City of Portland, Maine - Building or Use Permit Application

Permit No: 02-1202	Issue Date: OCT 30 2002	CBL: 336 L022001
-----------------------	-----------------------------------	---------------------

Proposed Project Description: Addition of 19' x 10' Mudroom	FIRE DEPT: <input type="checkbox"/> Approved <input type="checkbox"/> Denied	INSPECTION: Use Group: R3 Type: SB BOCA 1999
--	--	---

Floor Framing  
Sawna tubes

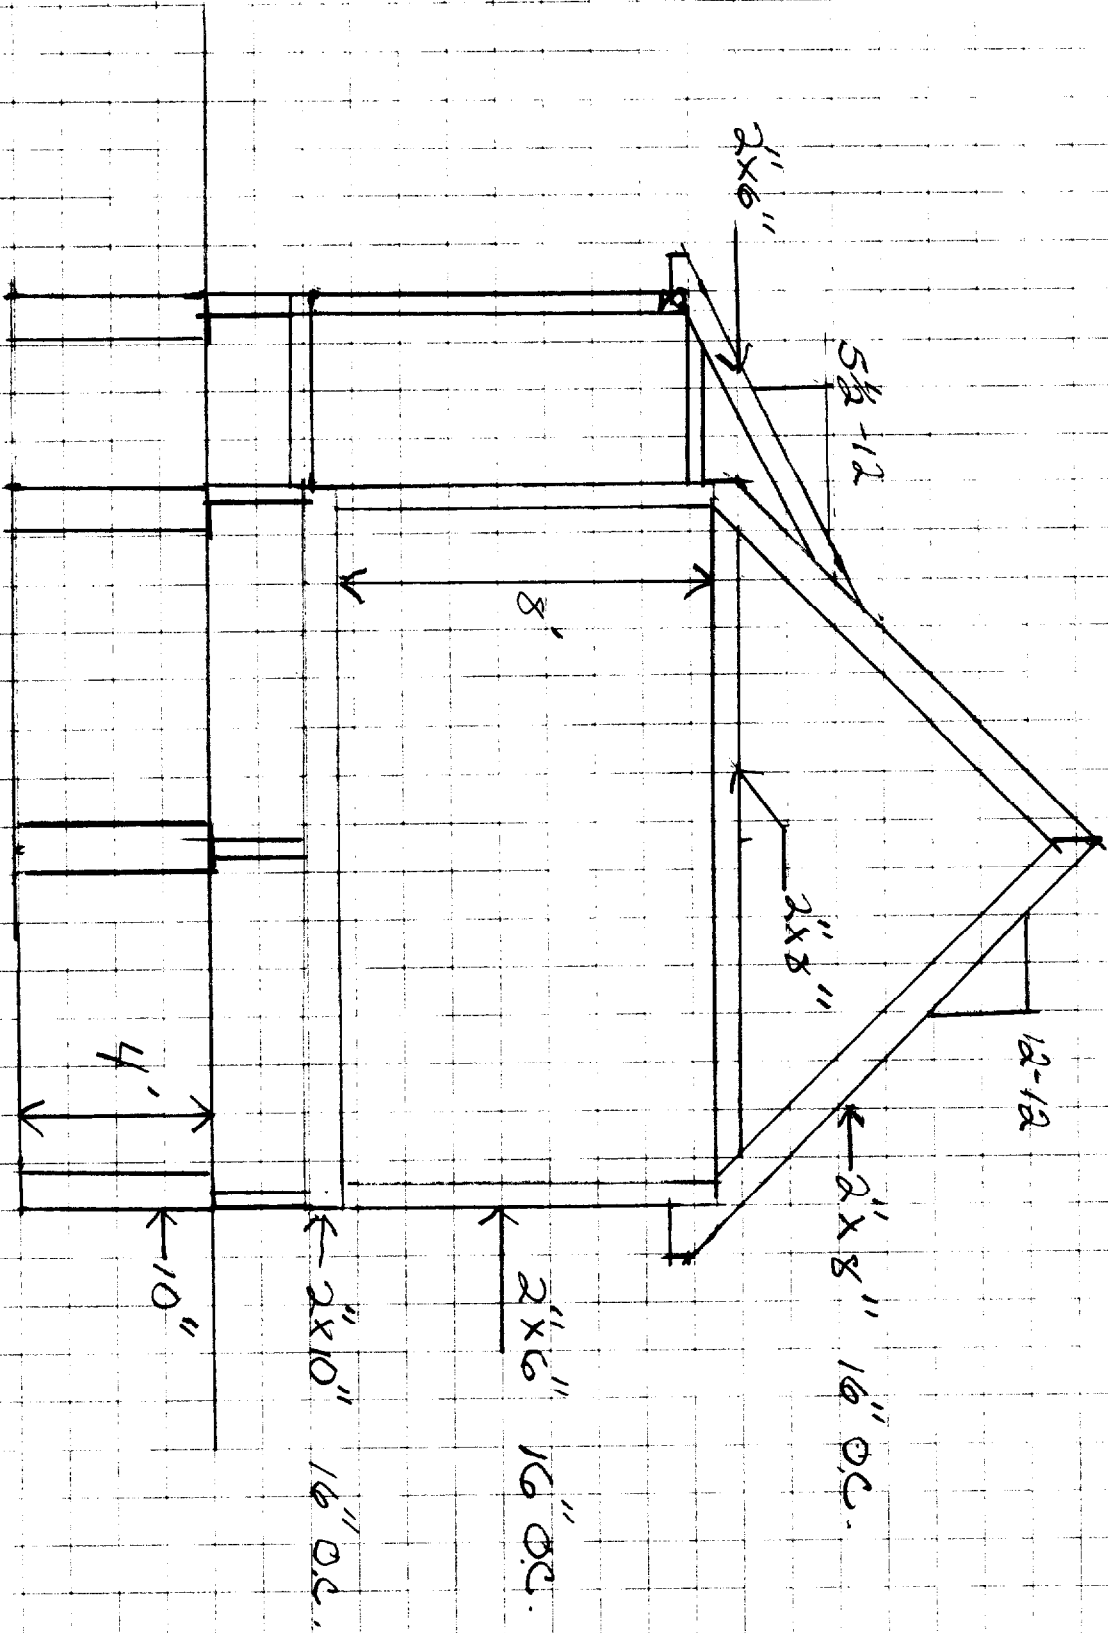
Comments: 10/29/02 left vm with John Mackie about # of porch footings, rims, fastenings, graspable h-rail & nosing/riser on stairs.

Per contractor, the perimeter rims on the 10' slides will be doubled, rim will be lagged to house, treads will have min. Required nosing, closed riser, and graspable h-rail. Stairs will be located at the front off the mud room
